Subject: LL-08-03; Lookout Large Lot (11 Lots) Frank & Judy Ragland
US 97, MP 140.76 Left; Parcel #18-17-01020-0005 (235.10 Acres)

We have reviewed the proposed subdivision, and have the following comments.

DWN BY DP/ST/GW	DATE 03/2008	JOB NO. 08009
CHKD BY D. NELSON	SCALE 1"=500'	SHEET 1 OF 3

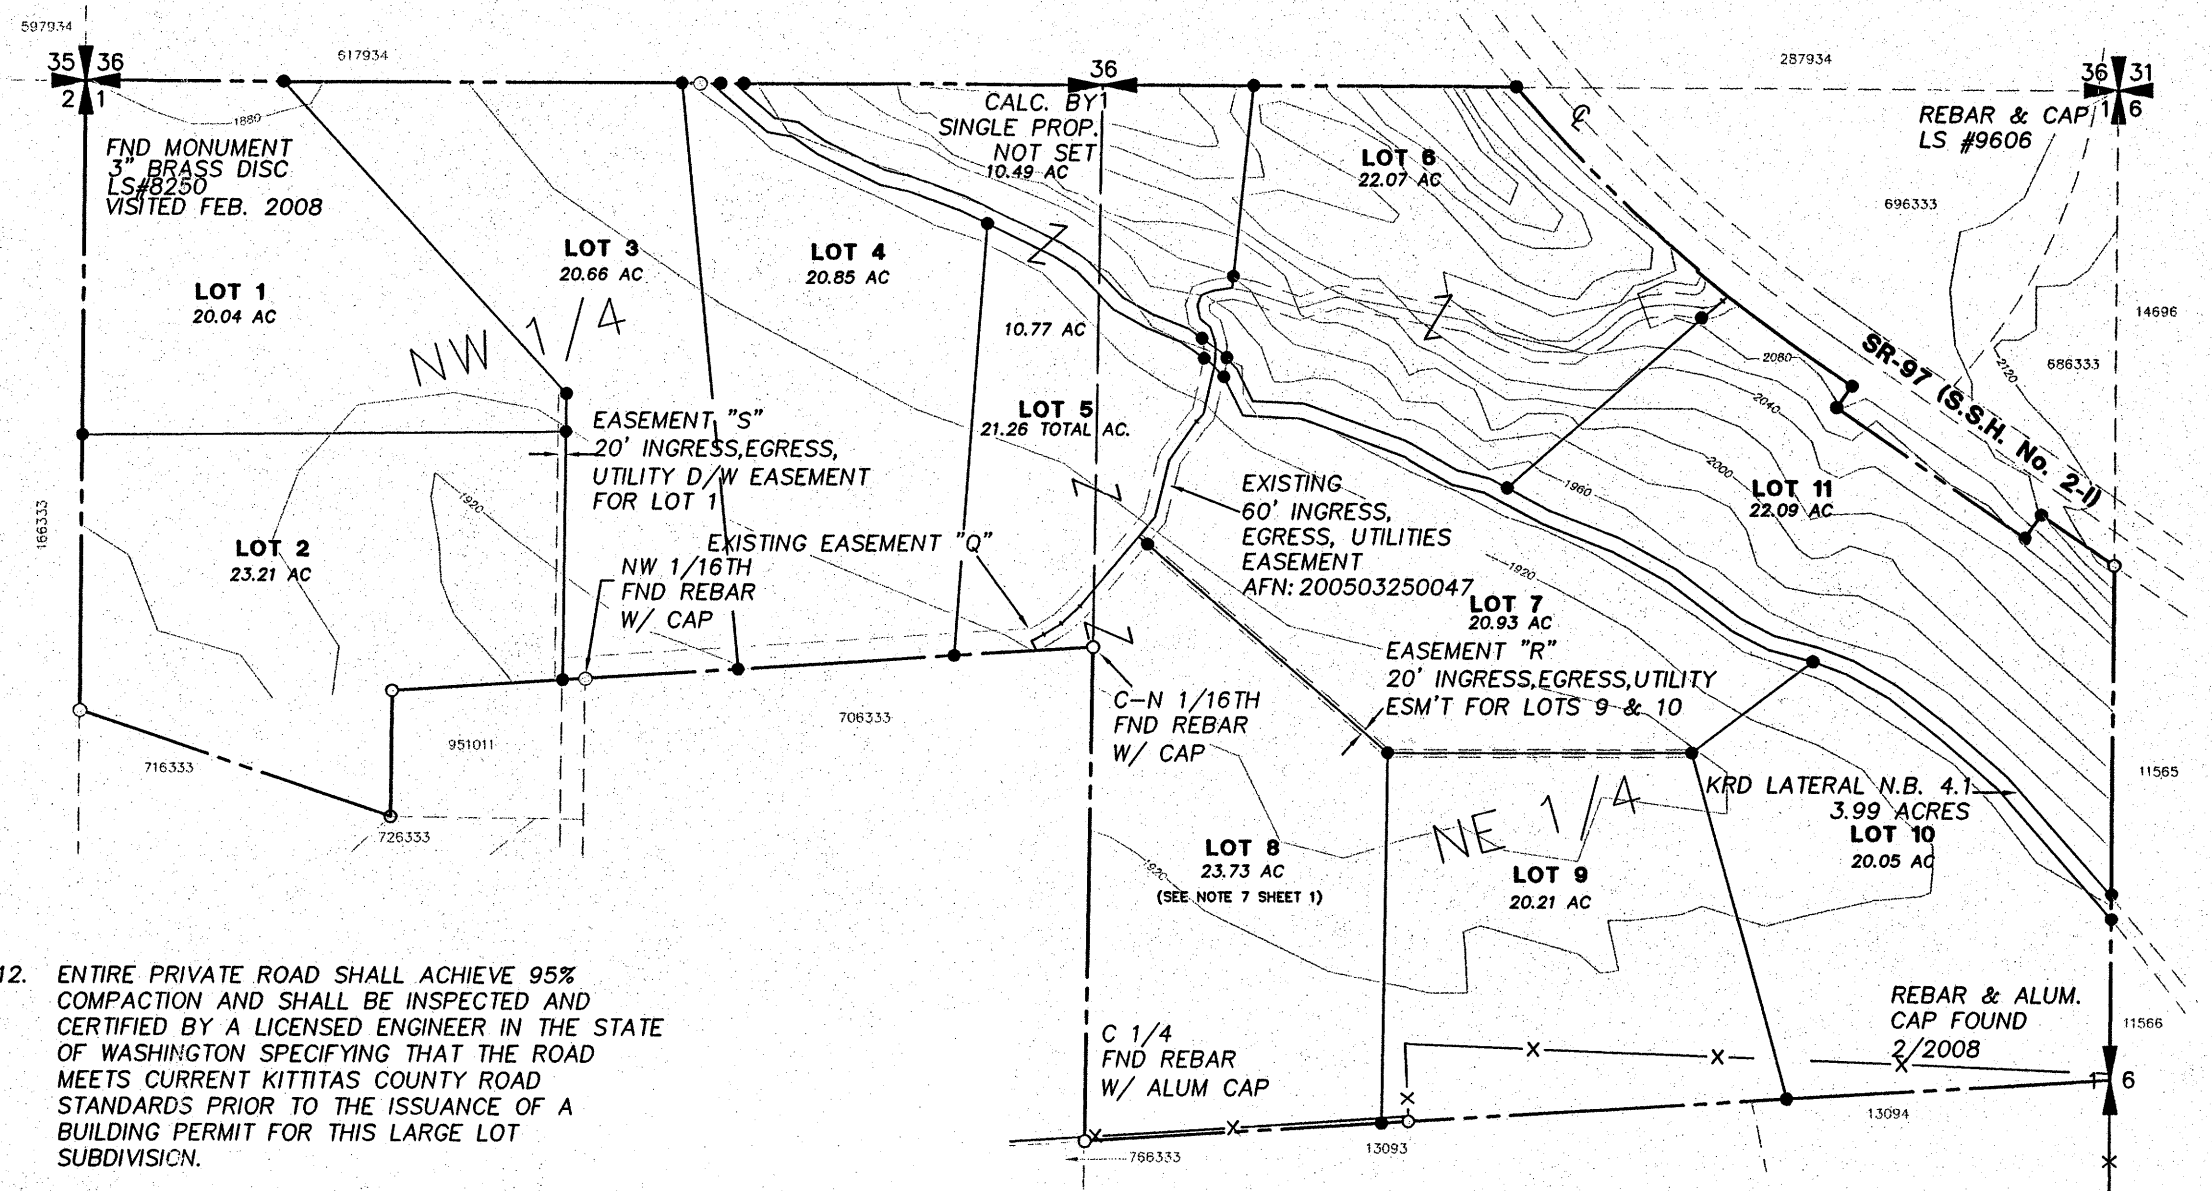
1. The property is adjacent to U.S. Highway 97. US 97 is a Class 1 access managed highway in this area with a posted speed limit of 65 miles per hour. The property has an existing approved approach connection at milepost 140.76 Left. All lots from this property must use this approach. The approach was approved on May 31, 2005, as permit number 44282. No additional access directly to US 97 will be allowed from the property. The approach is acceptable to accommodate the proposed subdivision traffic. No additional action is necessary by the proponent.

2. Stormwater and surface runoff generated by this project must be retained and treated on site in accordance with regulating agencies' standards, and not be allowed to flow onto WSDOT rights-of-way.
